# CITY OF ALBUQUERQUE

October 21, 2015

**RE: APS Montgomery Complex, 3315 Louisiana Blvd NE (G18D048)**  
**Drainage Master Plan**  
**Engineer Stamp Date: not Stamped**

PROJECT NO: 1460006901
DESIGNED BY: EEV
DRAWN BY: EEV
CHECKED BY: EEV
DATE: AUG 2016
SHEET TITLE
**FULLY DEVELOPED
SITE PLAN
FIGURE 4**
SHEET NO:
PAGE 9

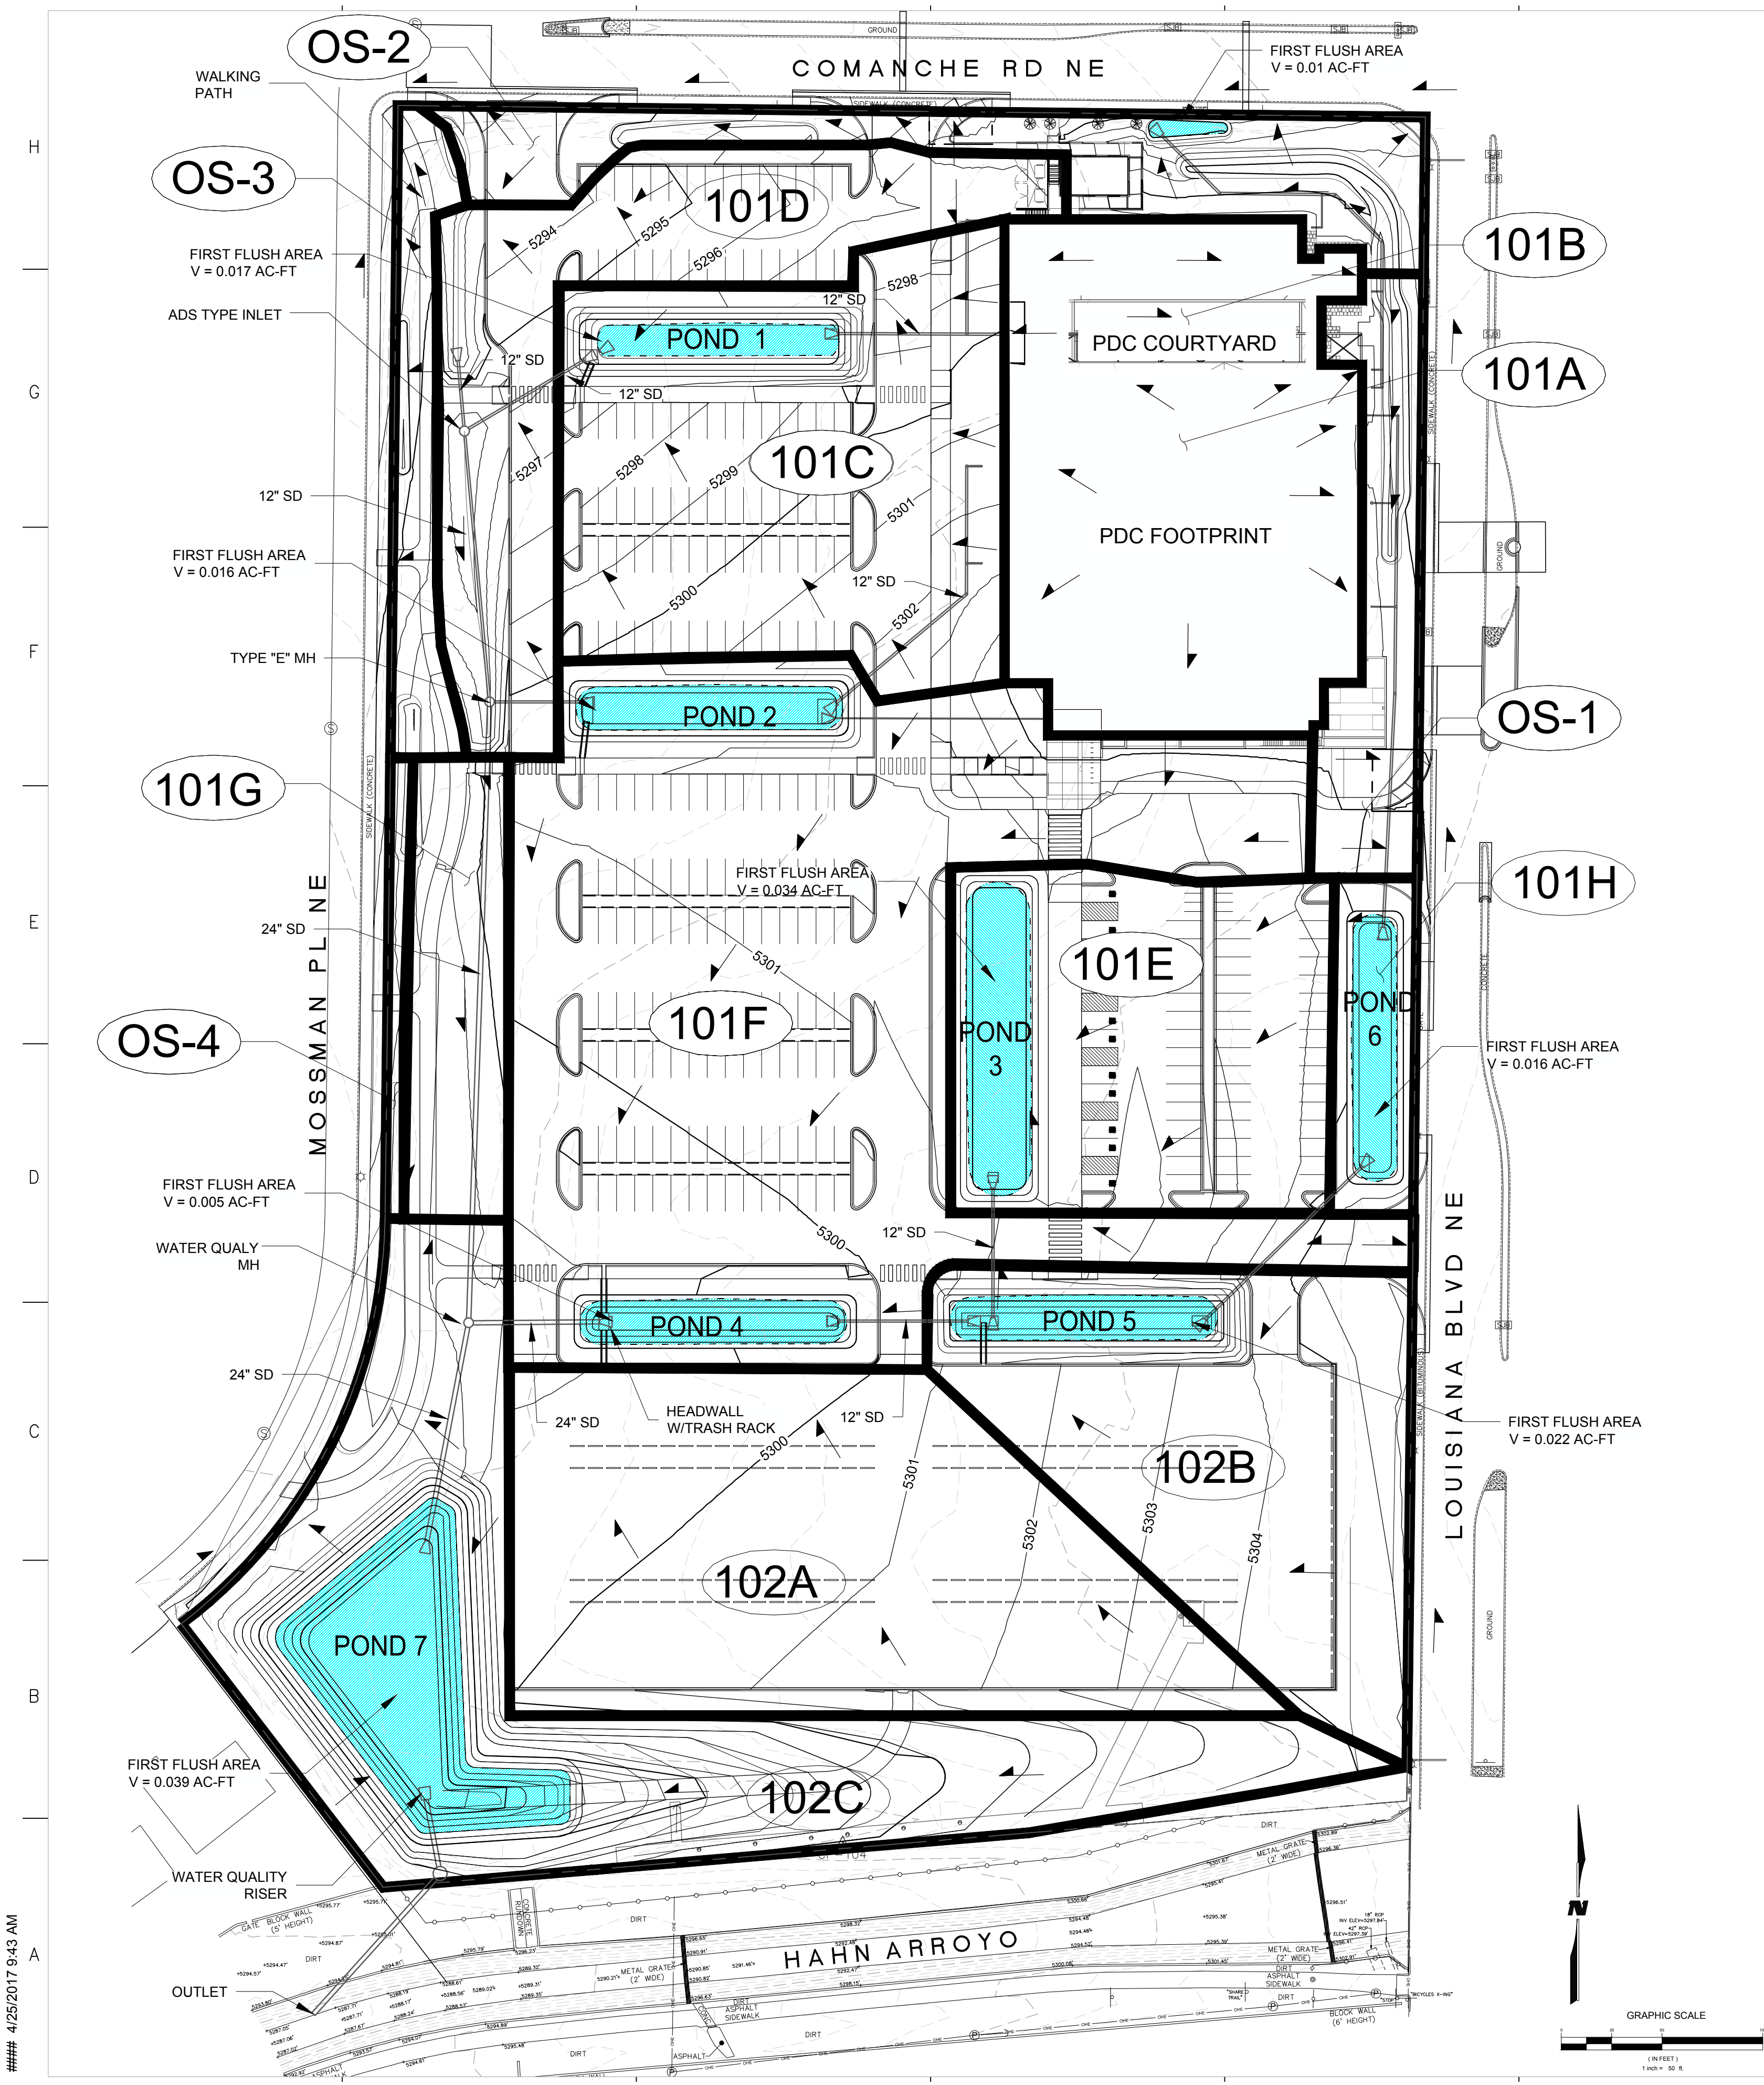
2. DMP needs to be stamped by the Engineer of Record.
3. Section 1.1 refers to Fig. 4, the Conceptual Grading Plan and Storm Drain Plan, but it is not included. Fig. 4 is a Proposed Site Map.
